From: Nick Scott [REDACTED]
Sent: 08 September 2015 15:21
To: Planning
Cc: Alison Meeus; Derek Whittington
Subject: Planning Application BN/29/15/PL (Public Rights of Way Comments) F.A.O Richard Temple

Figure 4 - Public Rights of Way (PRoW) Network

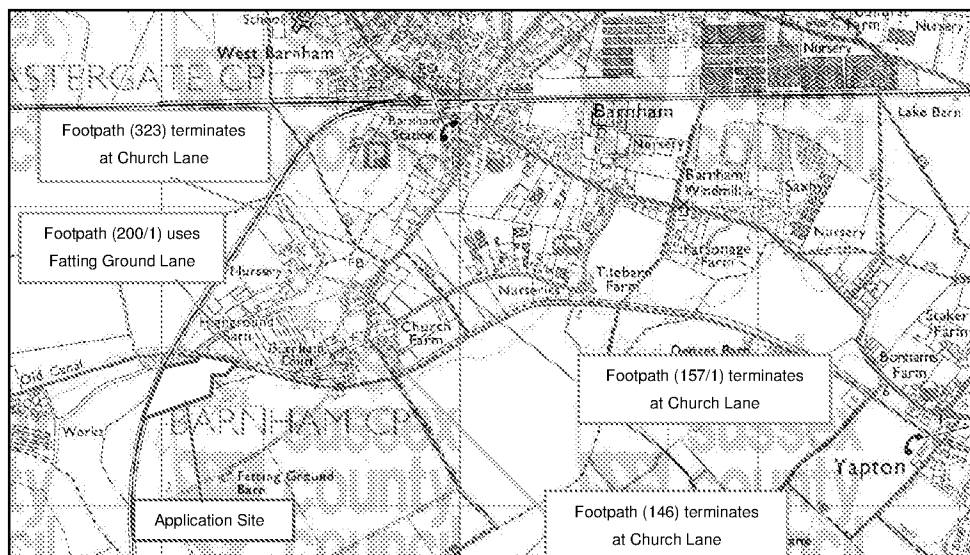
From a public right of way point of view clarity would also be welcome on what route of vehicular access will be available when travelling west from the red line, toward the site of the solar farm. The line of FP200/1 actually runs along the southern edge of the old canal and becomes a raised bank the further west it goes and it is hoped that the proposals are for vehicular access to be gained on the old northern bank of the canal, safely away from the legal line of the footpath and pedestrian users. This would seem the most sensible option as

the footpath is not very wide but if this could be clarified that would be appreciated. If it was the case that access was being granted along the legal line of the footpath then surface improvements would be required so the route was useable all year around, even though it was experiencing considerable vehicular use.

## FP146 & 200/1 - Felpham

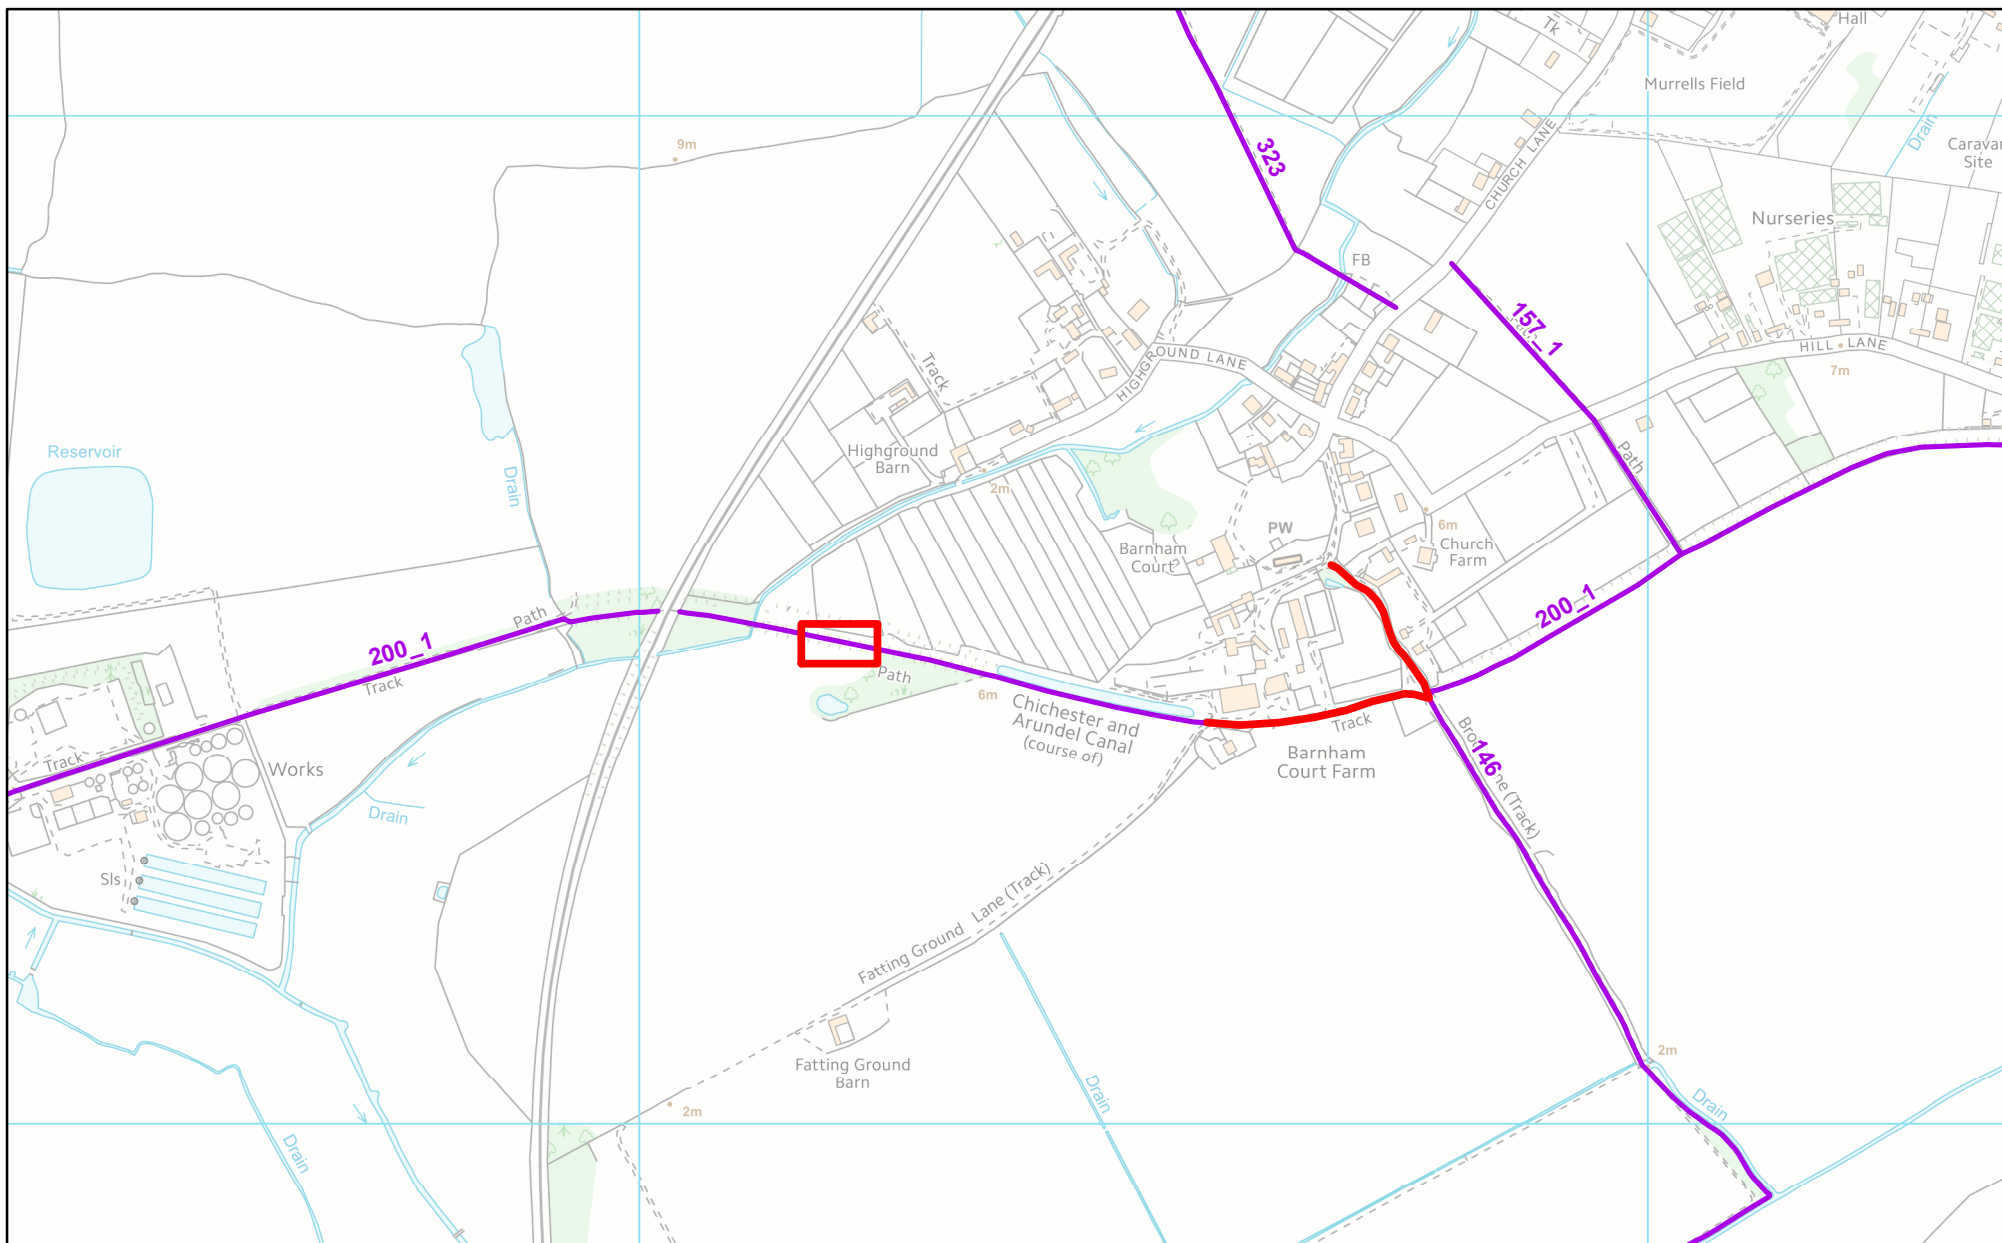
The final issue relating to the access itself would be the point it crosses FP200/1 (as shown roughly by the red square on the attached plan) into the actual site of the proposed solar farm. There is a clear crossing of the legal line of the footpath and due to the works taking a reasonably long time to be completed, and future access being required for maintenance it would be required for a stone surface to be laid at the point where the two routes cross so it is useable all year round even though vehicles are using it. If left as an unmade surface this route will become impassable to lawful pedestrian users when wet and this would be unacceptable. A specification for such surface improvements would have to be agreed with the PROW team at WSCC before works took place. At this crossing point where the access to the site and the public footpath cross, signage would be required informing that the public right takes precedent over the private vehicular right and also warning of the potential conflict along the entire east west section where vehicles will be moving close to lawful pedestrian traffic on the footpath.
